**Maxwell Underground Coal Mine Project (SSD-9526)  
Request for Additional Information**

I refer to the above application. Following further review and consultation with relevant agencies, the Department has identified several areas where additional information is required (see **Attachment A**).

Figure E-21: Predicted maximum 24-hour average PM_{2.5} concentrations due to emissions from the Project in Scenario 3 ($\mu\text{g}/\text{m}^3$)

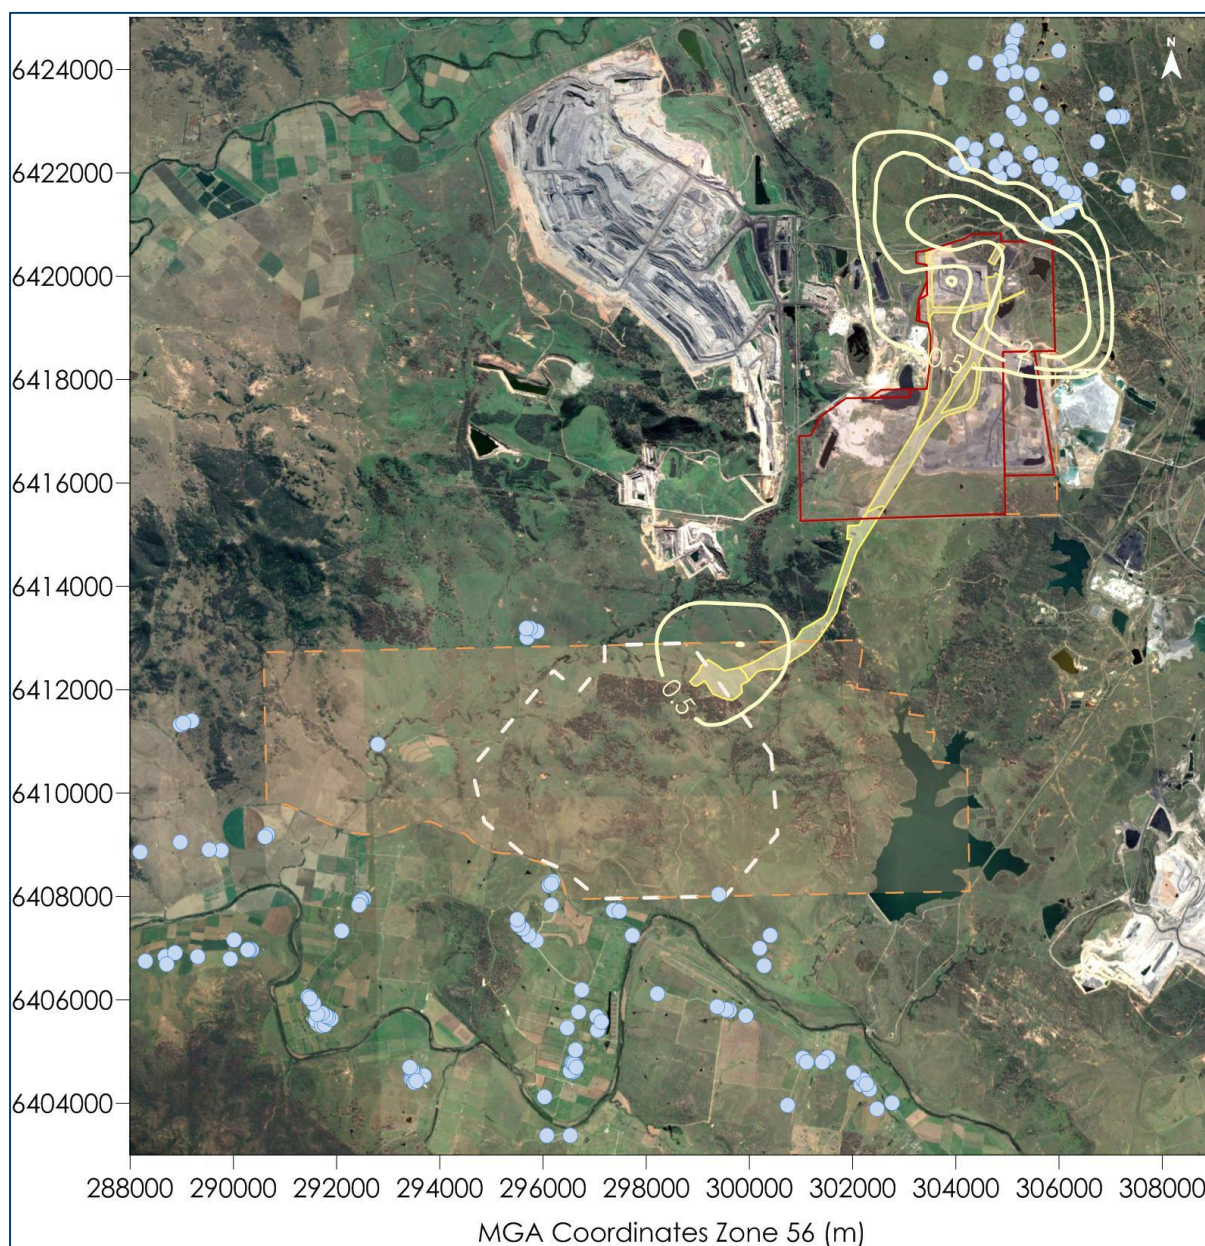
6. Please provide high-resolution versions of Figures E-21, E-23, E-24 and E-26 from Appendix J of the EIS. Please include receiver numbers for the receivers closest to the Maxwell Underground and Maxwell Infrastructure sites on these figures.
